Reference 2382/APP/2023/2906

Location BROADWATER LAKE MOORHALL ROAD HAREFIELD

Proposal Redevelopment of the site to create the Hillingdon Watersports Facility and Activity Centre including demolition of existing Broadwater Lake Sailing Club (BSC) clubhouse at the north of the lake and erection of a building to be occupied by HOAC and BSC including changing facilities, meeting rooms, storage, Workshop and seasonal worker accommodation (sui generis), activity shelters; installation of pontoons and concrete slipways; boat shed; equipment storage huts (north of lake and at entrance); boat parking and racking areas; camping area; outdoor activity areas; ecological enhancement throughout the site; new pedestrian routes through the peninsula; landscaping including new woodland, dense vegetation screens and boundary treatment; new access and access road; localised dredging and land reclamation; relocation of existing sailing area and creation of floating and fixed islands within the lake; coach drop off and turning area; vehicle parking; cycle parking; and associated works.

Figure 3.6: Site wide parking arrangements

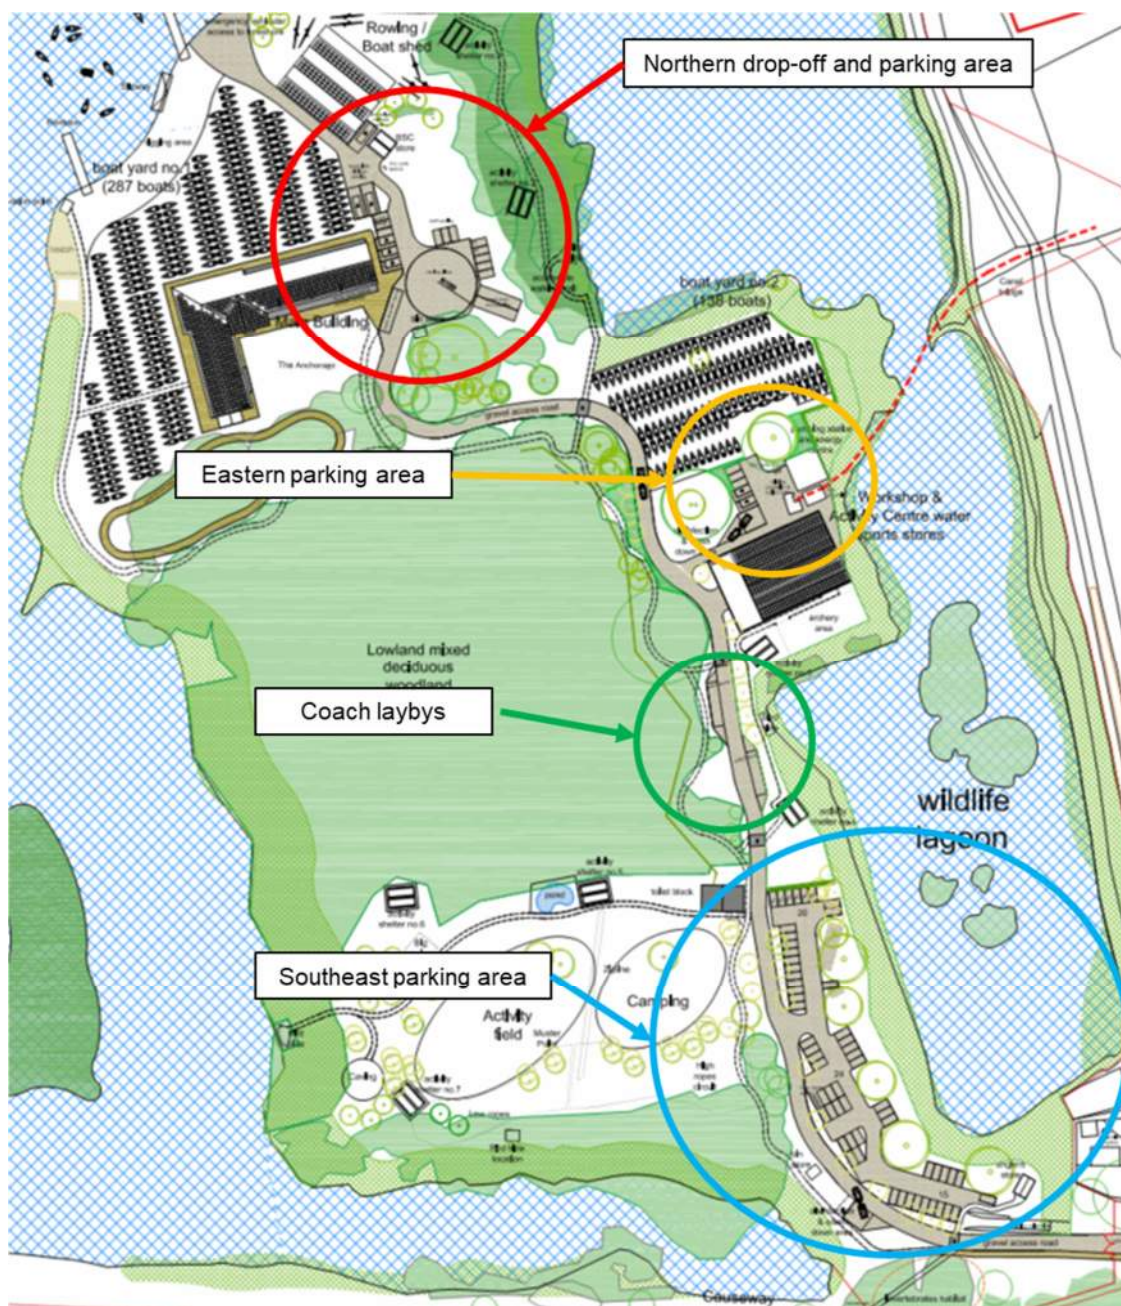
The development would provide a total of 18no. long stay cycle parking spaces and 24no. short stay cycle parking spaces. From the information provided it is not clear where the cycle parking would be located, a Parking Design and Management should be provided to clarify this matter and to confirm all long-stay cycle would be sheltered, secure and accessible.

The Highway Authority require a planning condition requiring that a Parking Design and Management Plan (PDMP) is submitted to the Council for approval. This should set out access, parking, drop-off and collection strategies for the site.

Appendix D – Access design general arrangement and swept path analysis

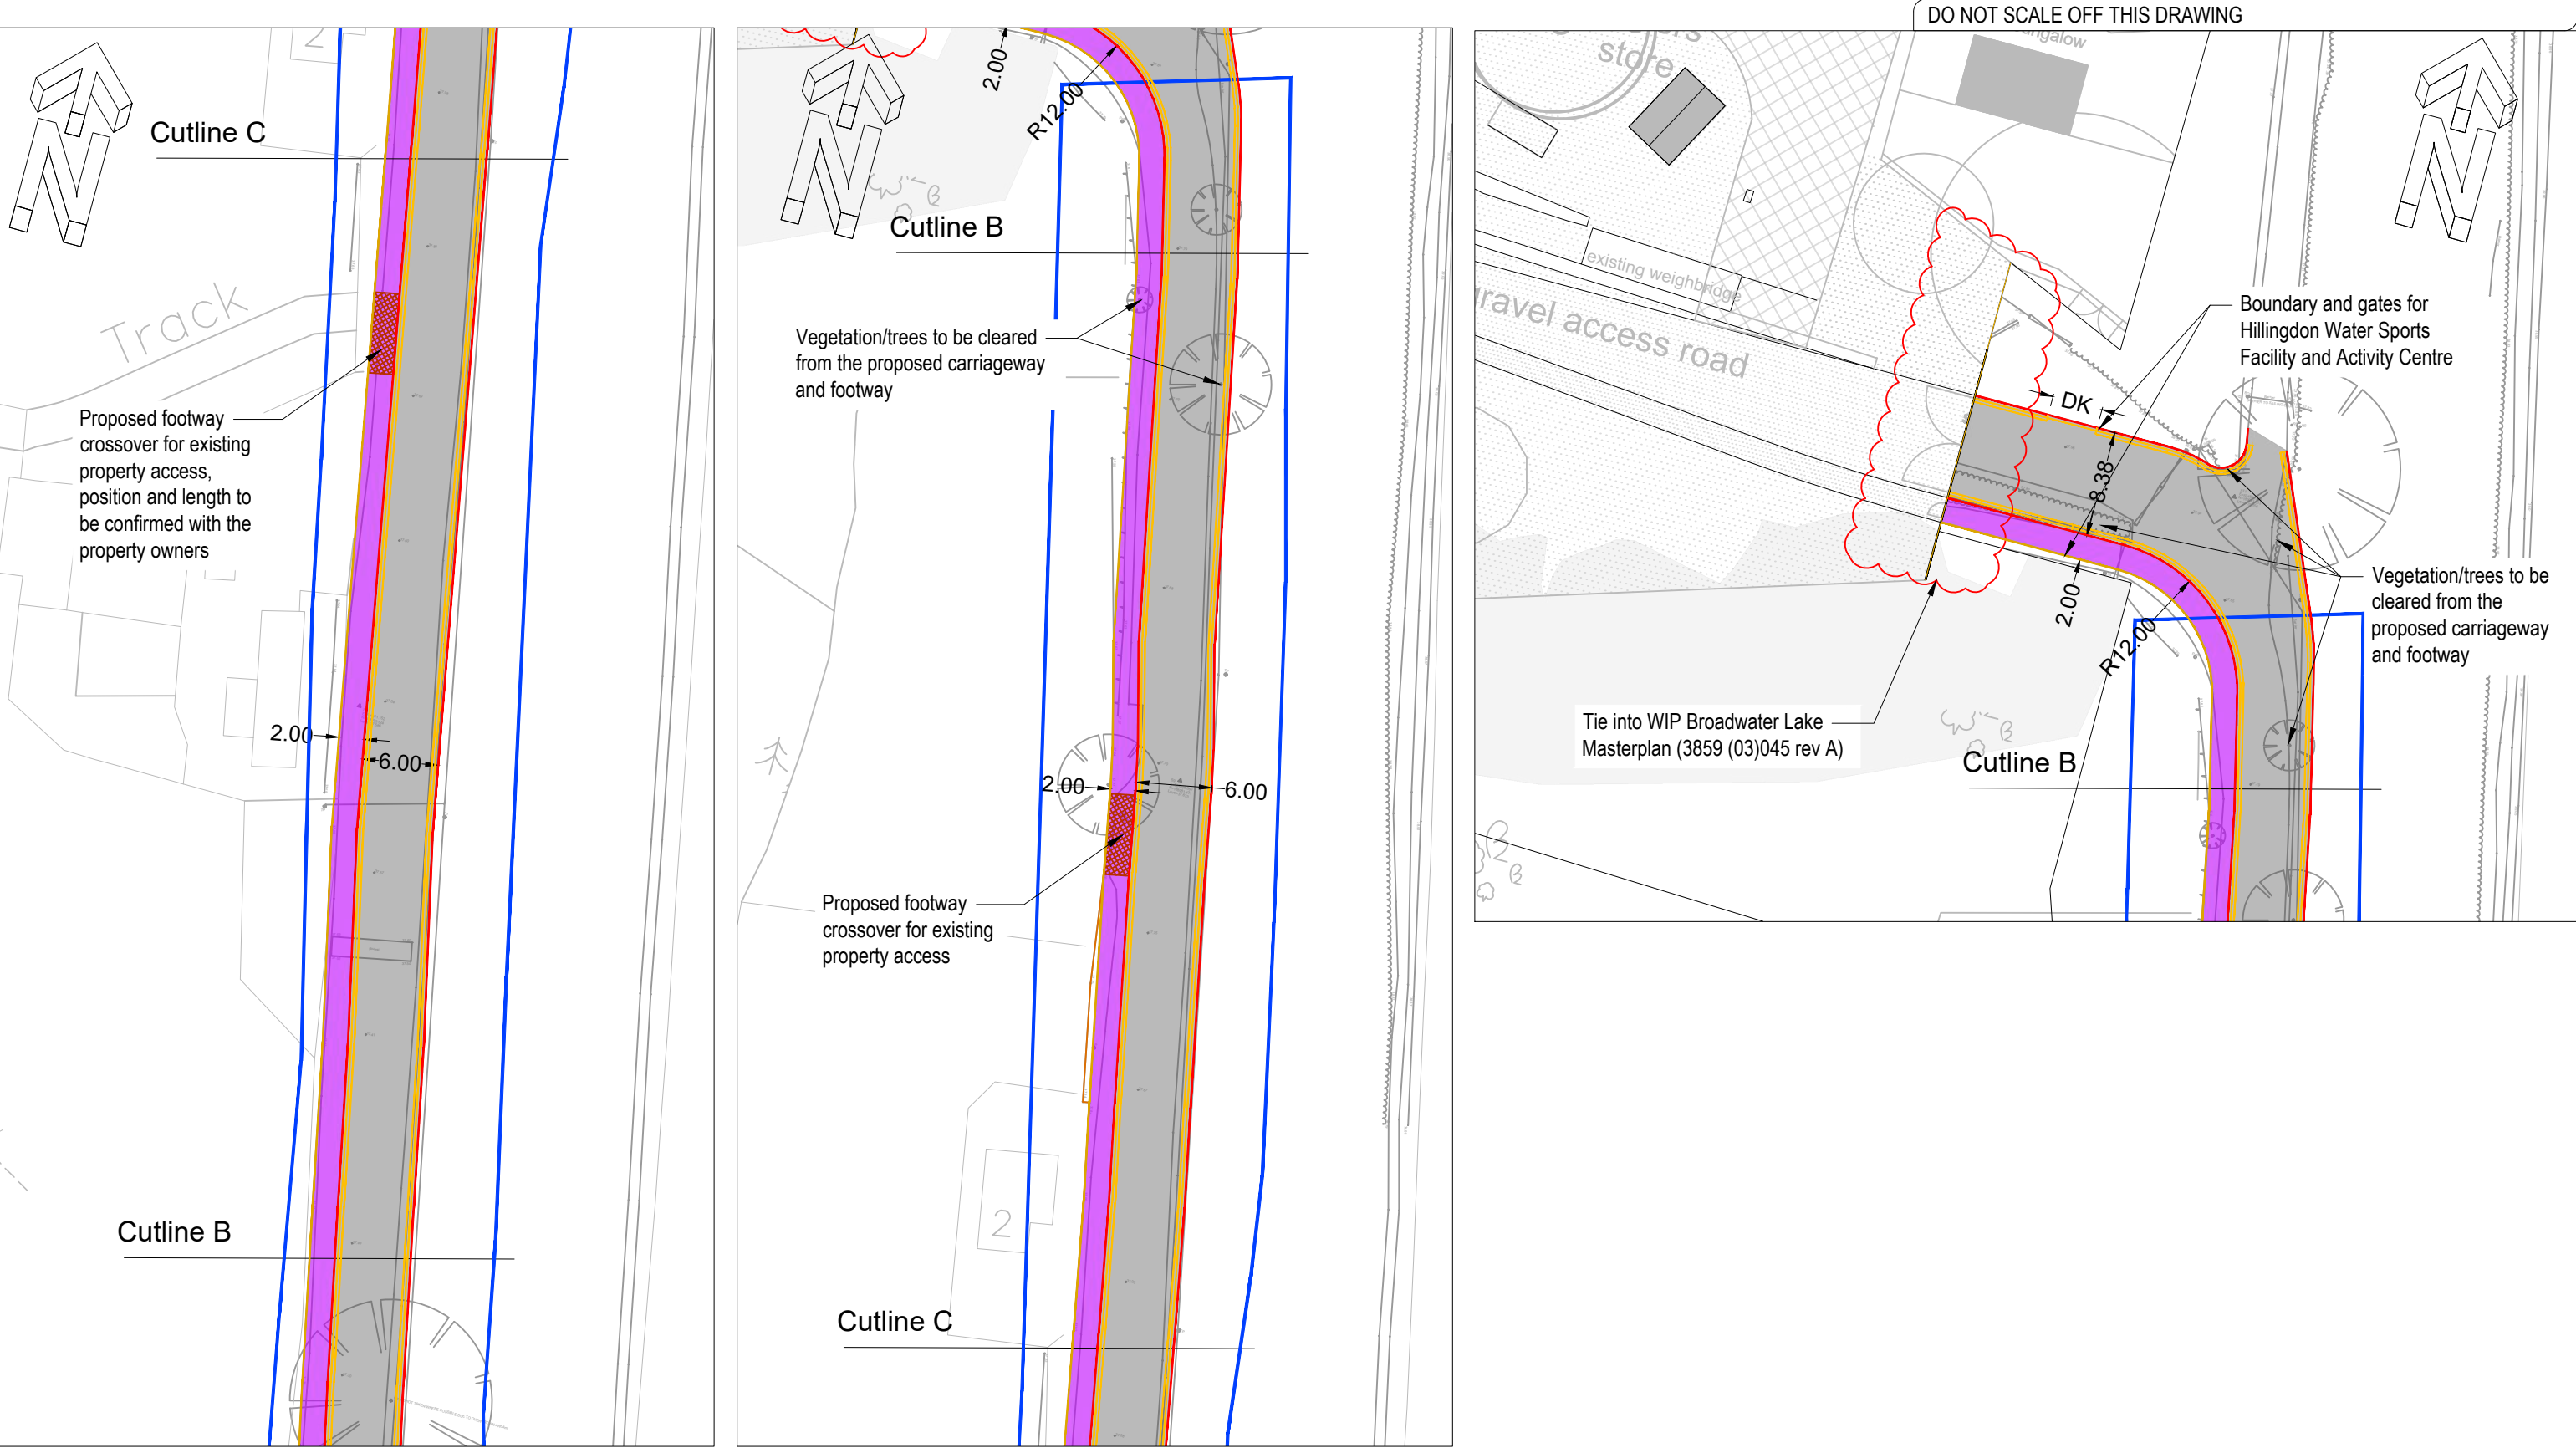
As part of the proposal the junction of the Boyers Pit and Moorhall Road would be remodelled, the width of the bellmouth would be increased to provide a larger turning radius in and out. In addition, the existing right turn pocket would be enlarged, this would allow coaches and other large vehicles approaching from the east to turn into the site without holding up traffic behind. To allow the Moorhall Road access to be remodelled and improved, the Highway Authority require a planning condition obliging them to sign a 1980 Highways Act s.278 agreement secured by a s.106 agreement of the 1990 Town & Country Planning Act.

The Highway Authority require that the applicant enters a 1980 Highways Act s.278 Agreement obliging them to remodel the junction of Boyers Pit with Moorhall Road including resurfacing and upgrading the footway towards the Broadwater Lock Grand Union Canal towards Harefield bus stop.
